EPC STORMWATER REVIEW COMMENTS
IN ORANGE BOXES WITH BLACK TEXT

OVERLOOK AT HOMESTEAD FILING NO. 1 PRE DEVELOPMENT GRADING AND EROSION CONTROL PLAN

OVERLOOK AT HOMESTEAD FILING NO. 1
 EL PASO COUNTY, COLORADO
 PRE DEVELOPMENT GESC PLAN
NOTES

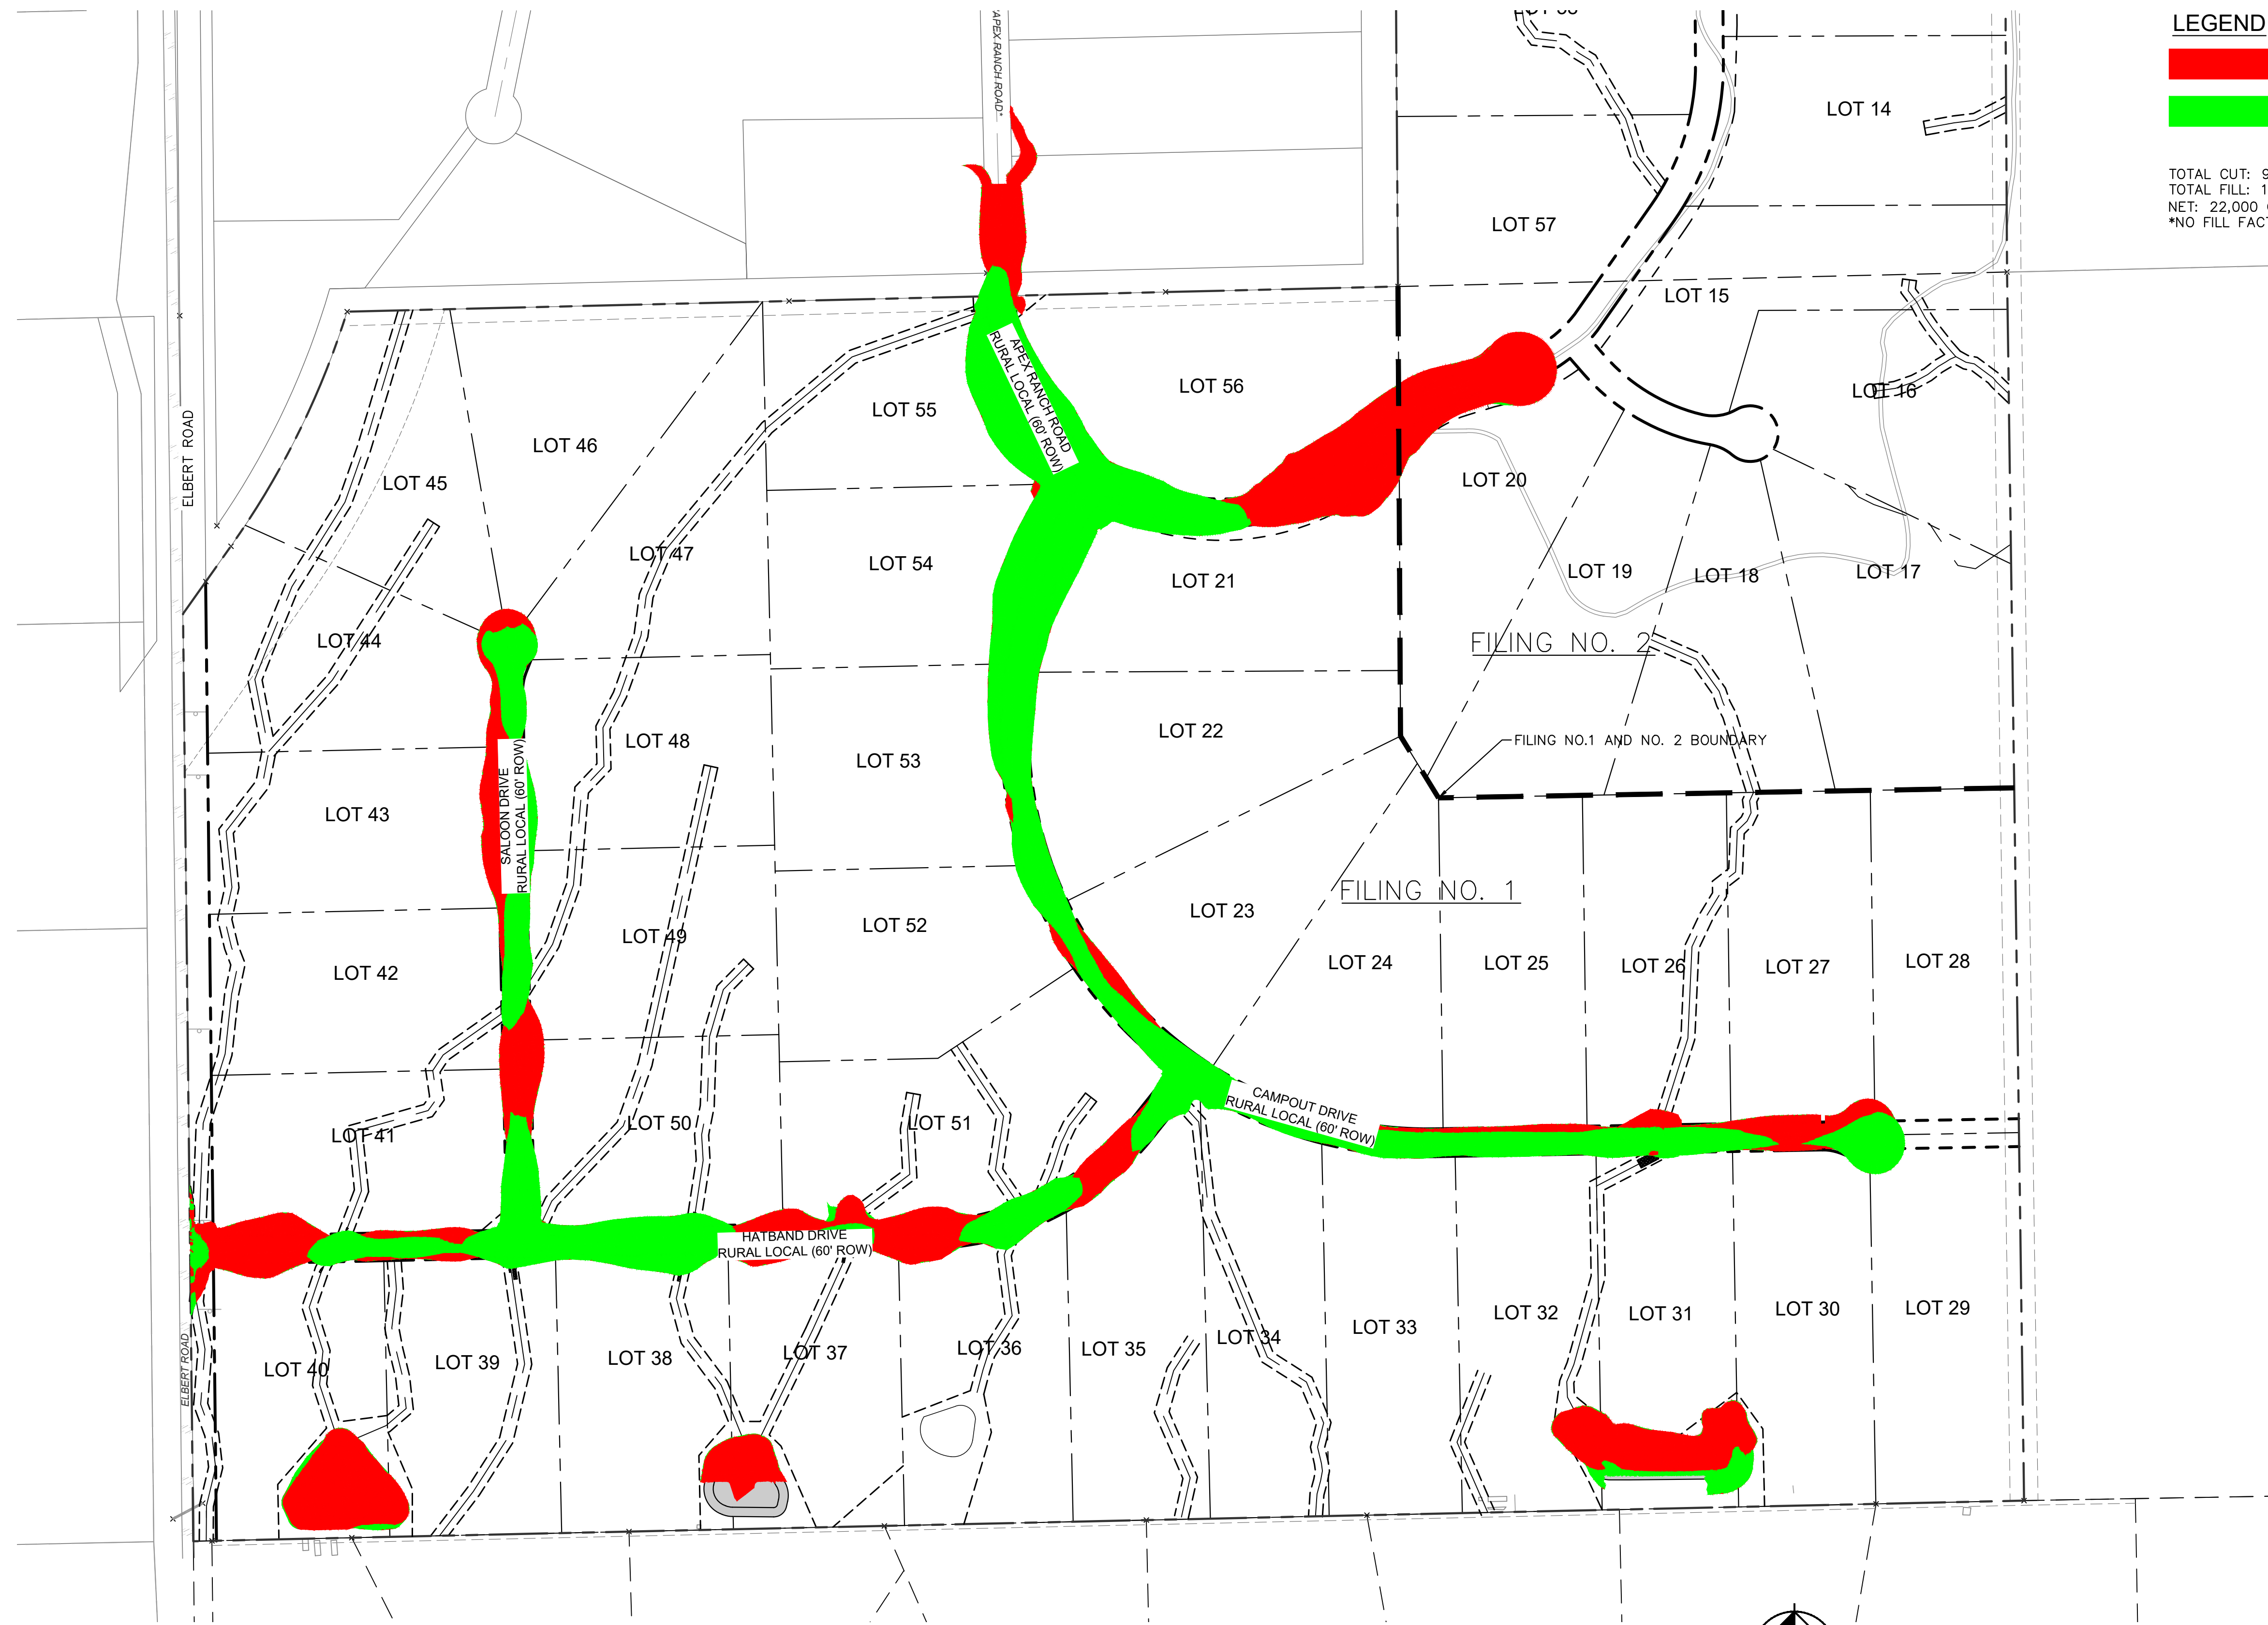
Update GEOTECH Report date

Geotech date updated

OVERLOOK AT HOMESTEAD FILING NO. 1
 EL PASO COUNTY, COLORADO
 PRE DEVELOPMENT GESC PLAN
CUT AND FILL PLAN

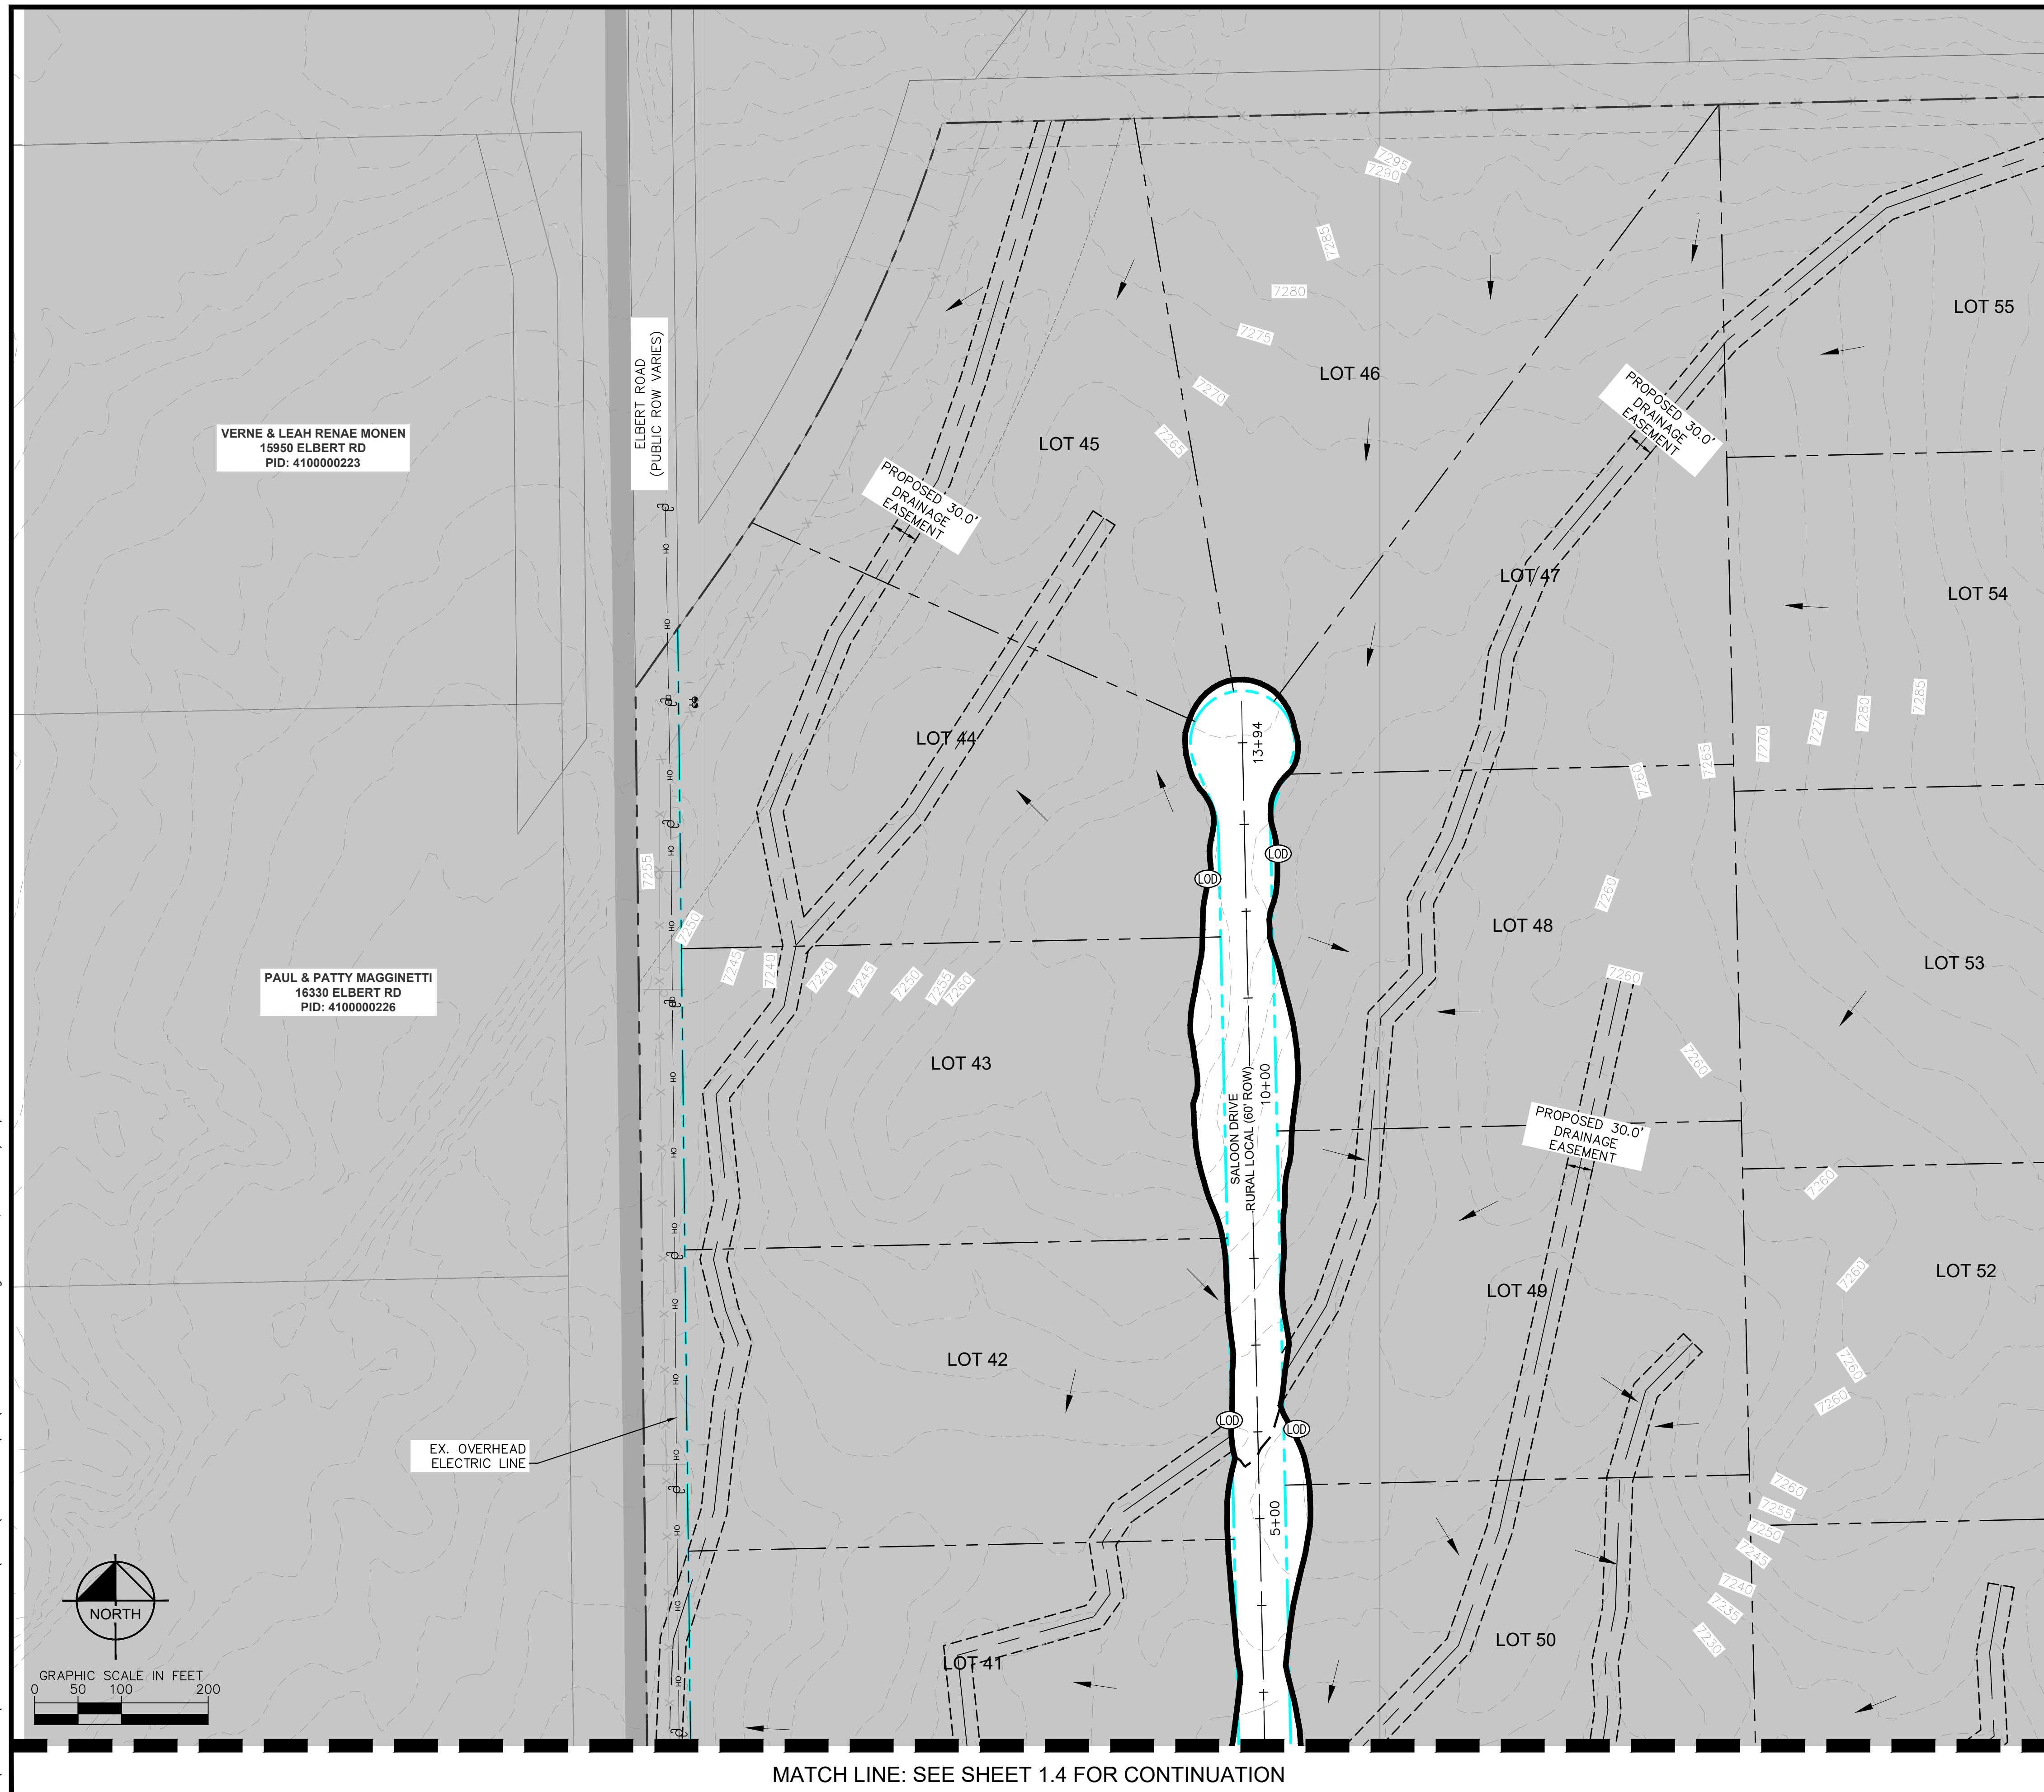
It appears that this area was not included in the FDR (basin OS-A2).

Area accounted for in previously approved FDR.
